**Re: St Francis Catholic College, 130-160 Jardine Drive, Edmondson Park
(SSD 8832)**

I write in response to your letter dated 9 July 2018 inviting Council to comment on the above State Significant Development proposal and advice on recommended conditions of consent.

Figure 11: Existing parking layout (67 car spaces) (DA-456/2016) (Sources: JDH Architects & Bitzios)

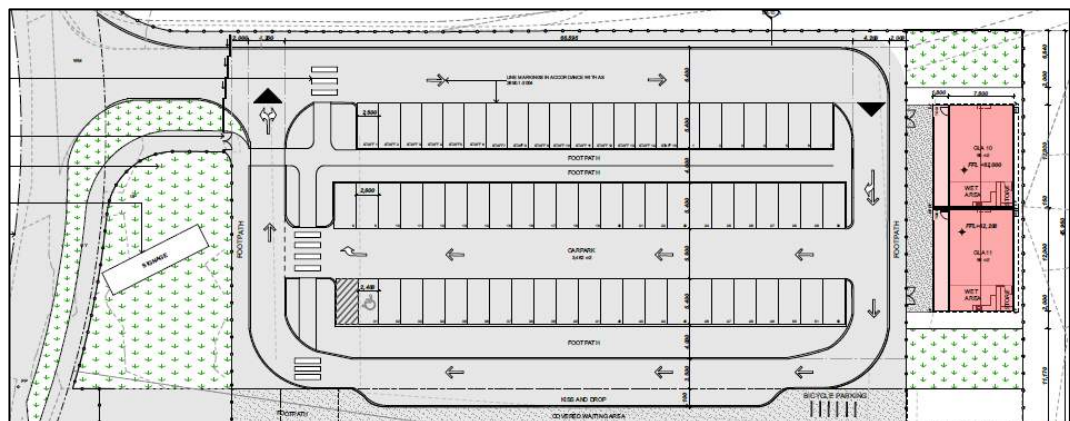
- Detail internal and external parking management and control including parking restrictions and delineation with signs and lines must be provided.
- Verify how the proposed queue length can be attained (i.e. 67 vehicle queuing capacity @ 1 vehicle per 2 minutes turnover = 2010 vehicles per hour) and address concerns about utilising the internal car parking aisle areas for queuing.

NORTH ELEVATION - POZIERS ROAD

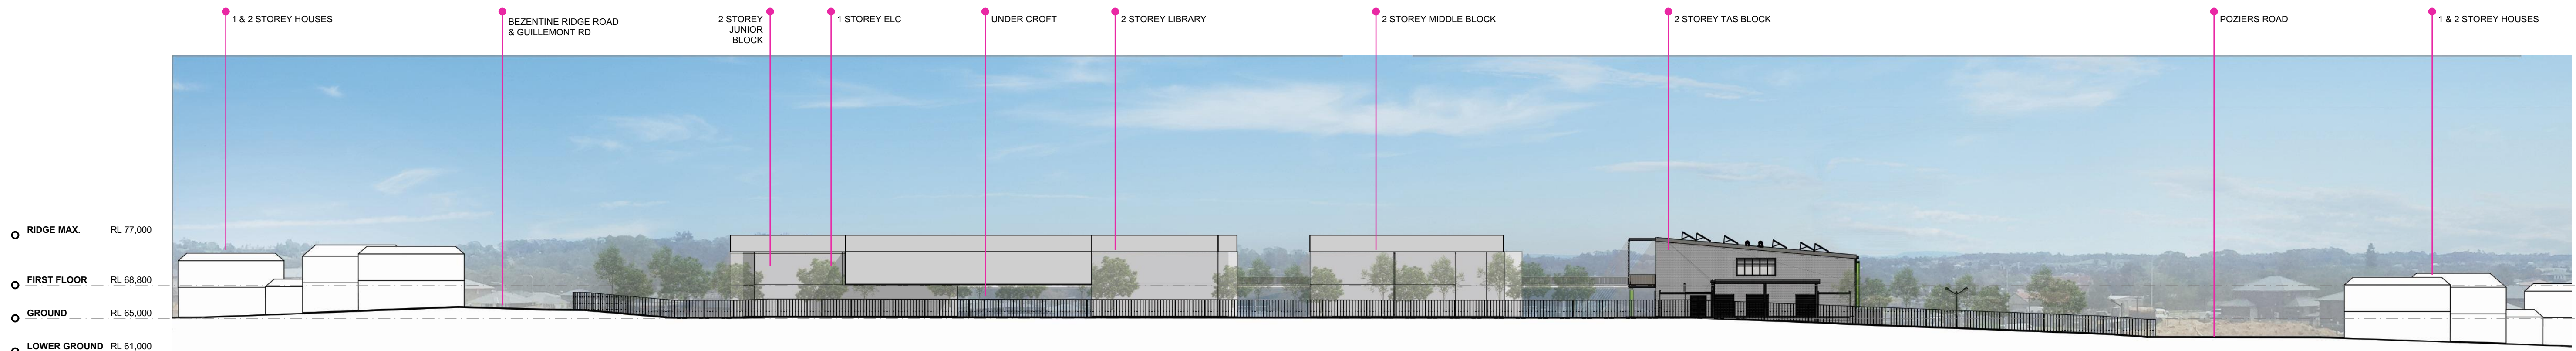
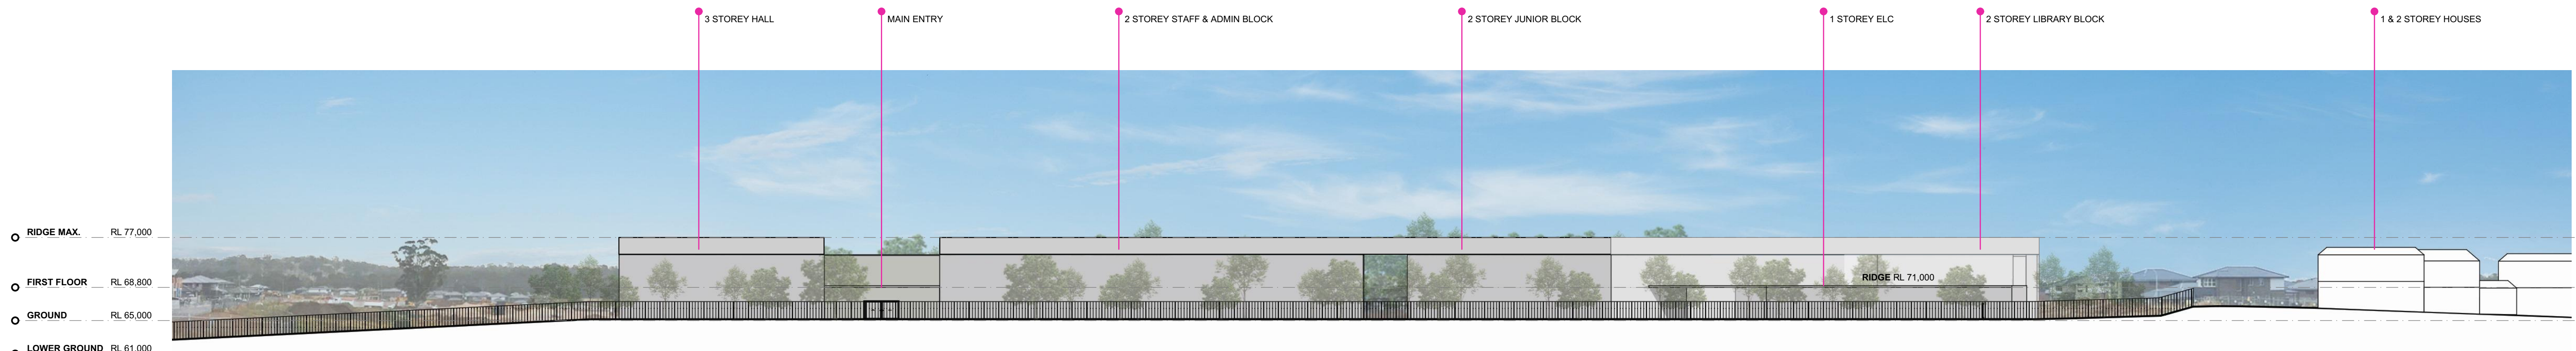
There are three storey buildings proposed on the site which has a 8.5m height limit (12m limit on the eastern and southern perimeter). Consideration is to be given to ensure that overshadowing and privacy impacts to low density residential areas are avoided.
